Rezoning Transportation Analysis

Petition Number: 2023-107

General Location Identifier: 10505203 & 10505201

Date	Description
10-25-23	First Review (ME)

RZ-1.0

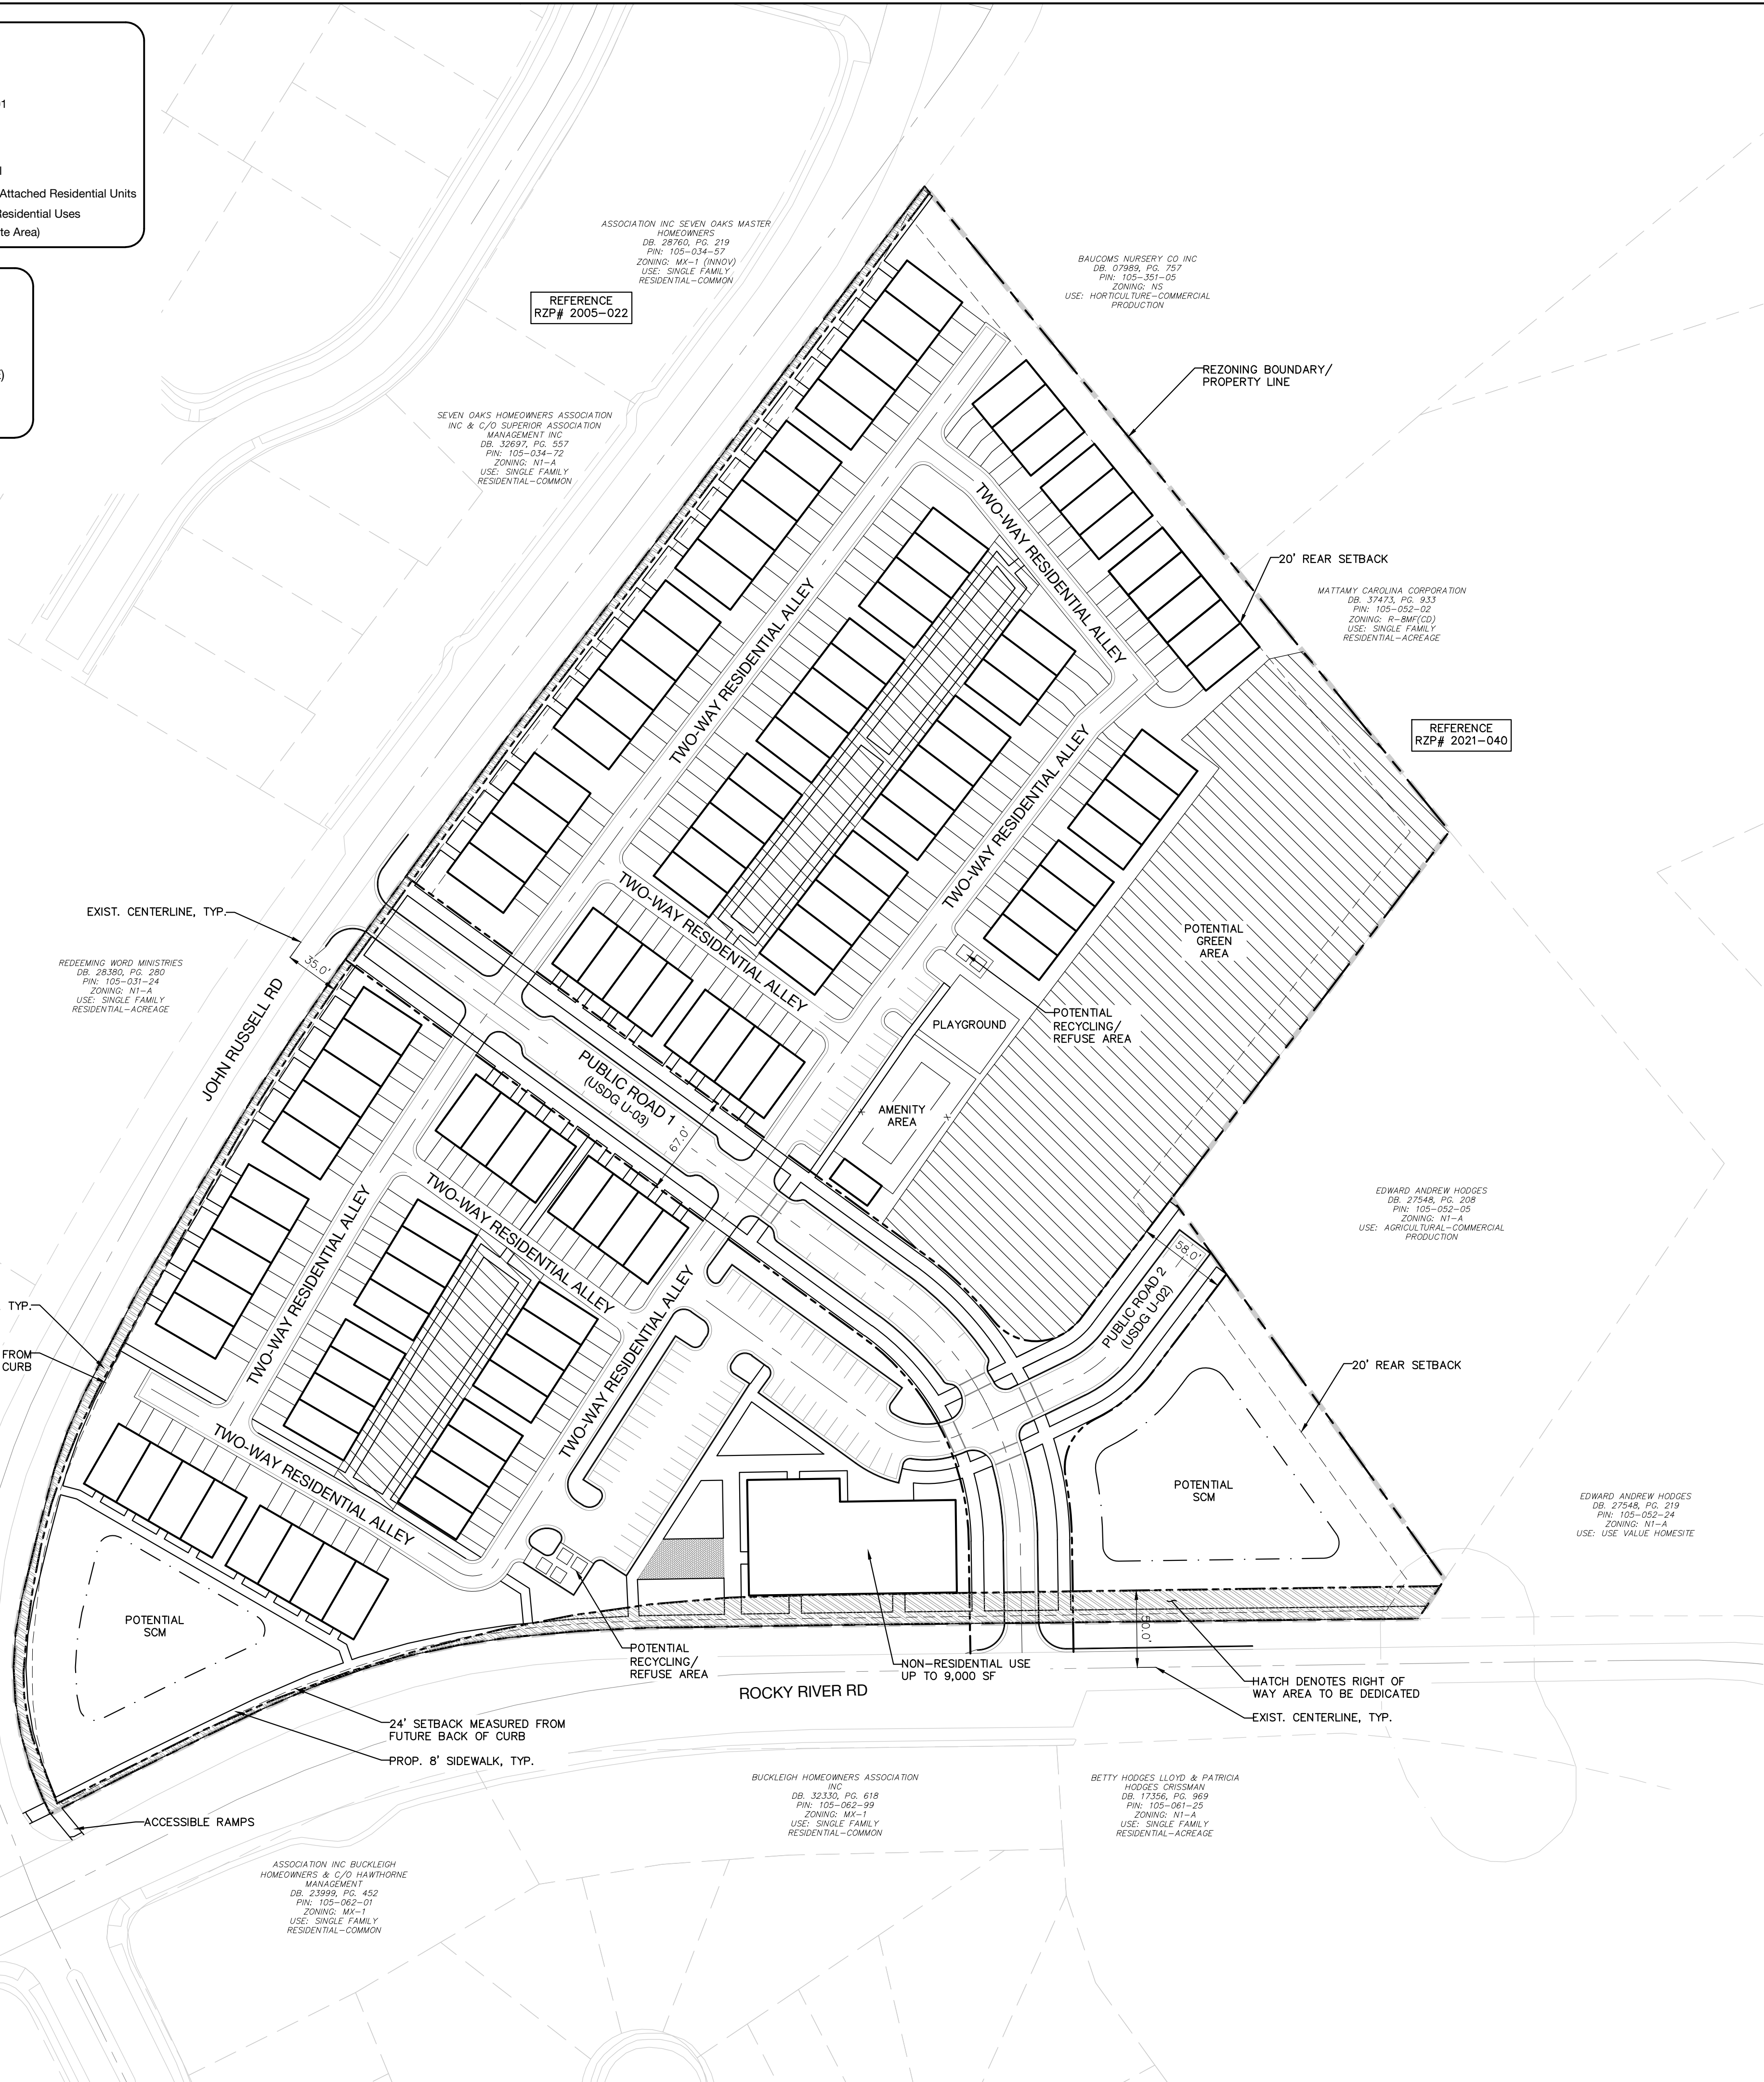
1. Curblines:

- a. **Rocky River Road:** Location of curb and gutter to be installed to 30 feet from roadway centerline to accommodate the Charlotte Streets Map with a roadway typical section of a 4 lanes or more arterial.
- b. **John Russell Road:** Location of curb and gutter to be installed to 19 feet from roadway centerline to accommodate the Charlotte Streets Map with a roadway typical section of a 3 lanes or less arterial.

Label and dimension the curb and gutter from the centerline for each road on the site plan.

Reference (CLDSM standard detail 11.09) for both street typicals.

3. Revise site plan and conditional note(s) to commit to dedicate 38 ft right-of-way from the road centerline for Rocky River Road and 27 ft for John Russell Road. The site plan shall label and dimension the right-of-way from the road centerline.

4. Revise site plan and conditional note(s) to commit to construct an 8-foot planting strip, and 12 foot shared use path on Rocky River Road per Charlotte Streets Map. The site plan shall label and dimension both items from the back of curb and gutter or edge of pavement.

5. Revise site plan and conditional note(s) to commit to construct an 8-foot planting strip, and 12 foot shared use path on John Russell Road per Charlotte Streets Map. The site plan shall label and dimension both items from the back of curb and gutter or edge of pavement.

7. Revise site plan and conditional note(s) to commit to installing ramps, crosswalks, and pedestrian signalization at intersection of Rocky River Road and John Russell Road in coordination with CDOT and NCDOT.

8. **CDOT REQUEST 10-26-23:** Revise site plan and conditional note(s) to commit to construct an 8-foot planting strip and 12 foot shared use path on Rocky River Road per Charlotte Streets Map between eastern property line and Bailey Run Drive to allow for access for pedestrians in neighboring developments to Reedy Creek Park.

9. Revise site plan and conditional note(s) to commit to making the access right-in and right-out access only on Rocky River Road, constructing a dedicated right-turn lane into the site with 100-feet of storage and installing a 4 foot concrete monolithic island on Rocky River Road in coordination with NCDOT.

10. Revise site plan and conditional note(s) to commit to making the access full movement on John Russell Road, constructing left and right turn lanes into the site on John Russell Road with 150-feet of storage and the appropriate tapers, and constructing a three-lane road section if proposed right turn and existing right turn lane taper onto Rocky River Road are within 100 feet of each other in coordination with NCDOT.

11. Revise site plan and conditional note(s) to commit to completing intersection sight distance survey in coordination with NCDOT.
12. Add a conditional note specifying "the Petitioner shall dedicate and convey in fee simple all rights-of-way to the City before the site's first building certificate of occupancy is issued. CDOT requests rights-of-way set at 2' behind back of sidewalk where feasible."
